Application No: A/26/21/RES
Site Address: Land west of Brook Lane and South of A259 Angmering BN16 3JL
Description of works: Approval of reserved matters following outline consent A/44/17/OUT for appearance, landscaping, layout & scale for the demolition of existing buildings on site & erection of a mixed use development comprising of 90 No. residential dwellings & a care home & ancillary facilities including railway crossing together with associated access, car parking & landscaping. This application also lies within the parishes of Rustington & Littlehampton.

Thank you for your internet representation made on 26th March 2021 which has been recorded as an objection with the comments as follows:

OWQC34730

2. Site Analysis
Site Access / Connectivity

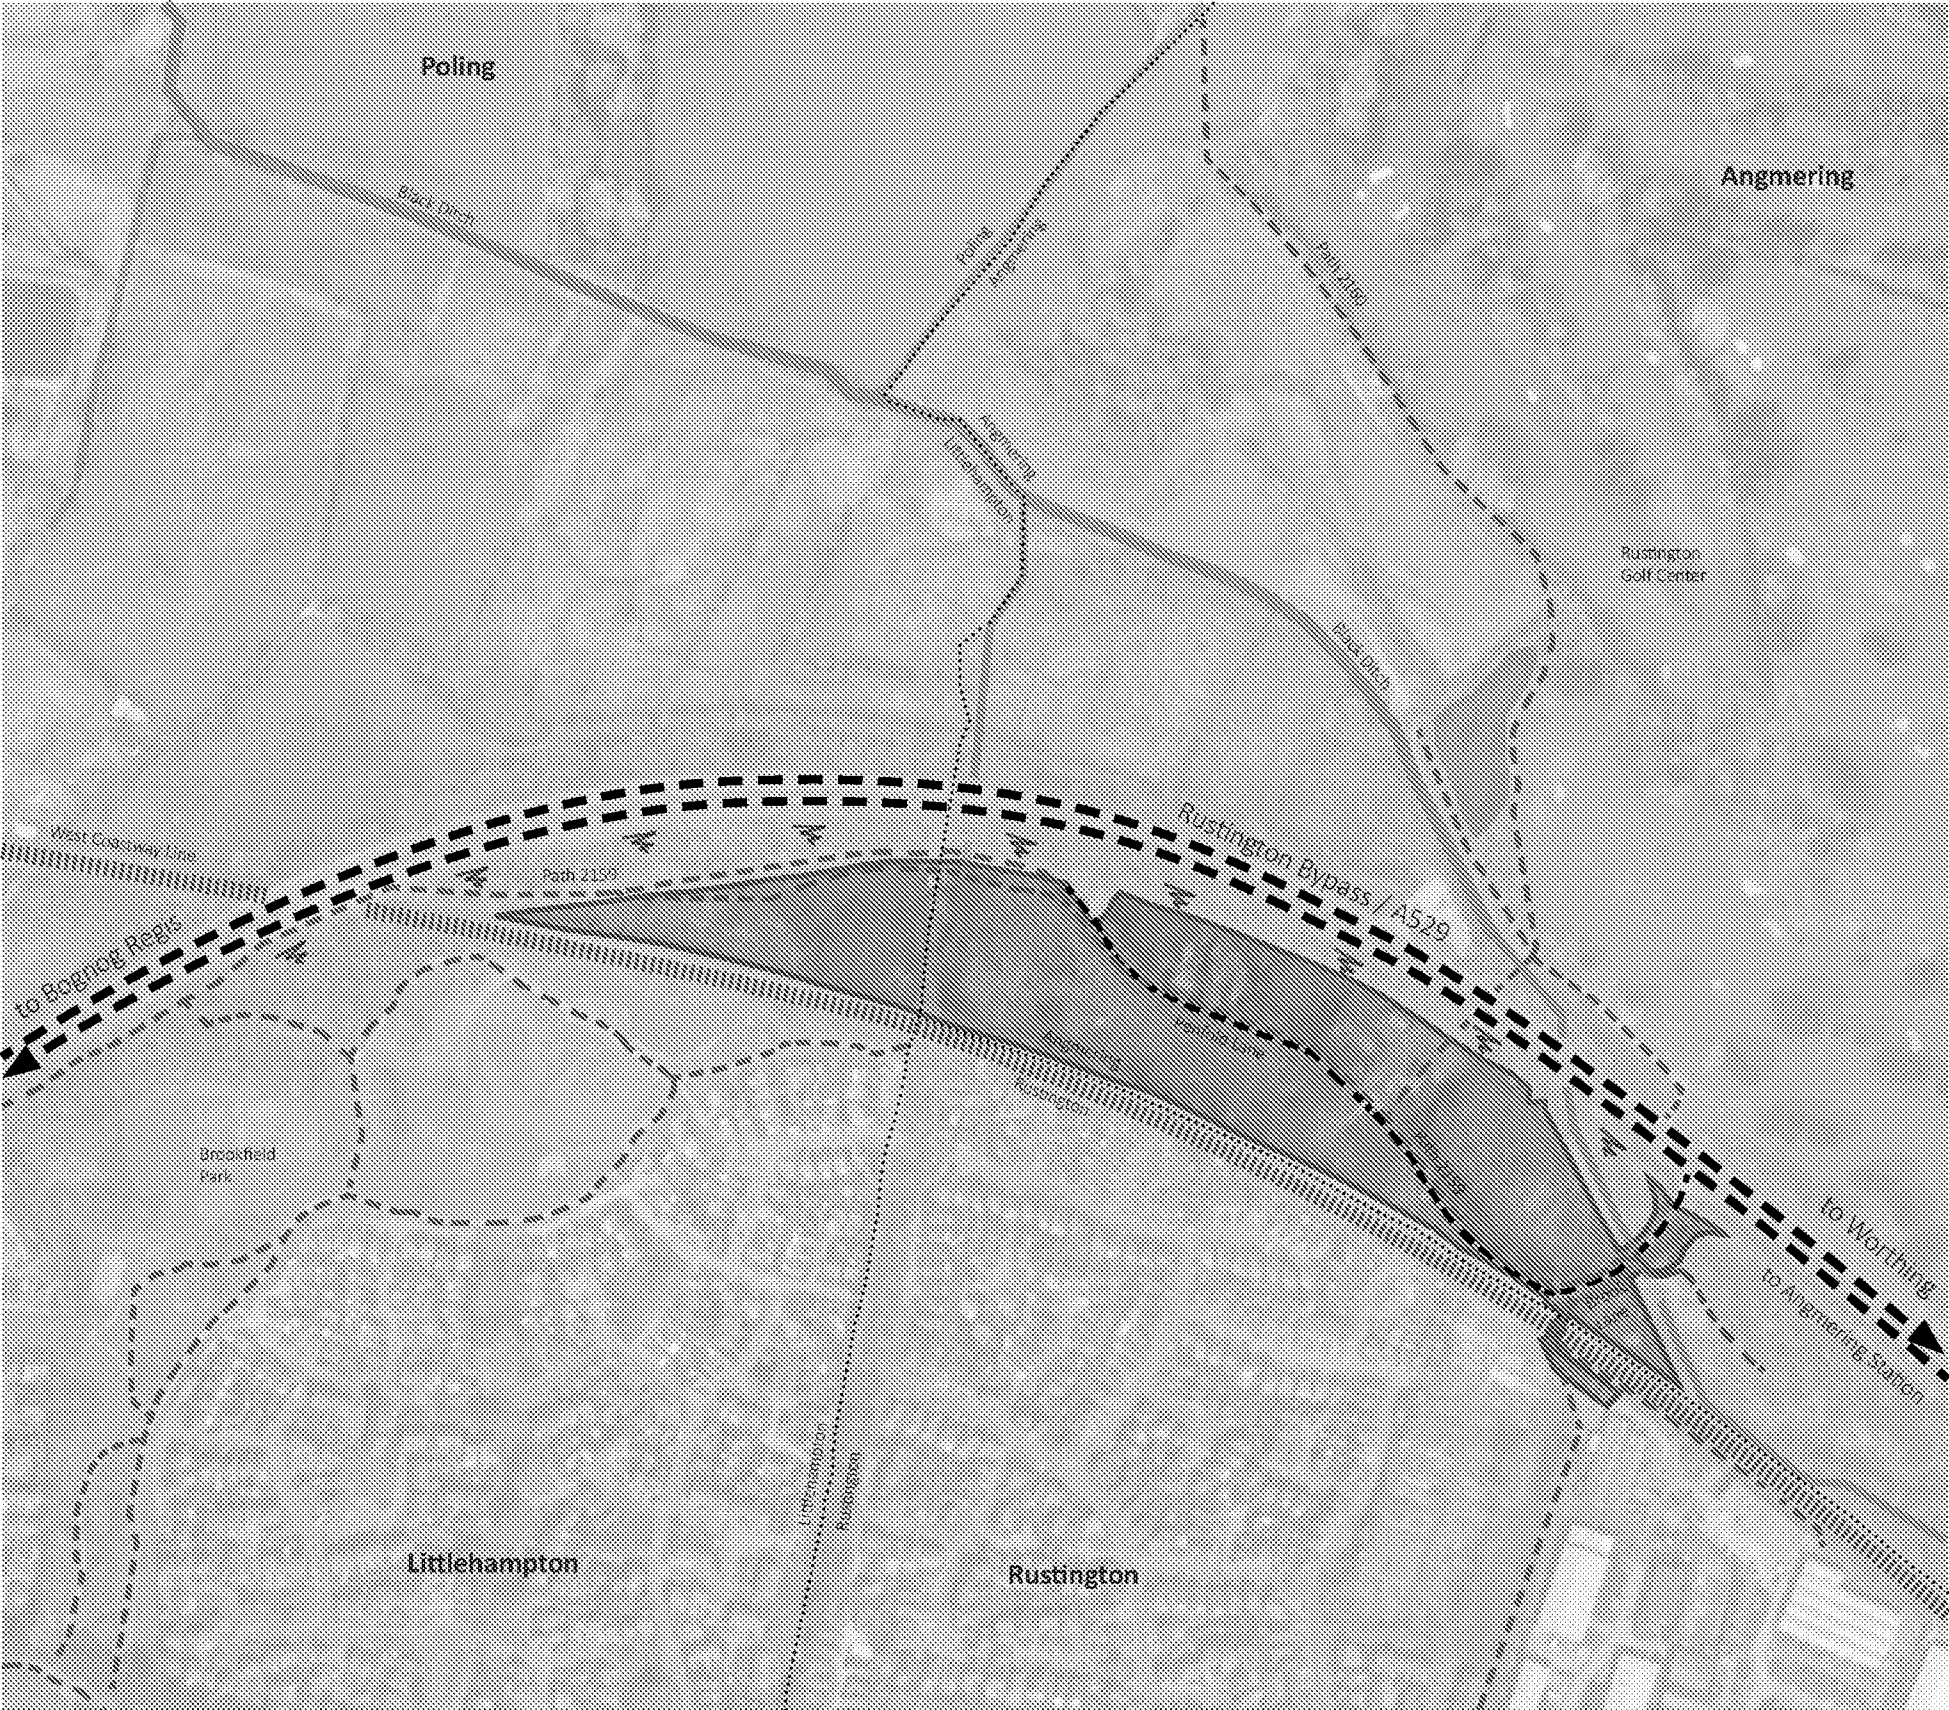
The construction of a bridge over the railway for pedestrian/cyclist use is welcomed but there is the need to emphasise that the use of Penfold Lane (Footpath No. 2159) in any plan is not suitable. The Lane is in a very poor state of repair, insecure with no surveillance or lighting, generally unfit for purpose and, most certainly hazardous for the type of use that would prevail once the bridge was constructed. Maintenance is almost non-existent as the Highway Authority's (West Sussex County Council) responsibility is to purely ensure that it is kept clear for pedestrian access.

With public safety at the forefront of its mind, my Council is particularly concerned that at most times of the year the Lane is used by a large number of vehicles, to access its Allotment Site at the northern end, on a daily basis. With no specifically determined pedestrian path along the Lane, it would be impossible to protect pedestrians from the hazards that would, most certainly, be experienced when using the Lane for the stated purposes.

My Council believes that Penfold Lane should not, therefore, be considered suitable to be used as the pedestrian access route from the railway bridge to the schools, bus services and shops, until measures have been imposed for it to be brought up to the standard necessary to address all of the above concerns.
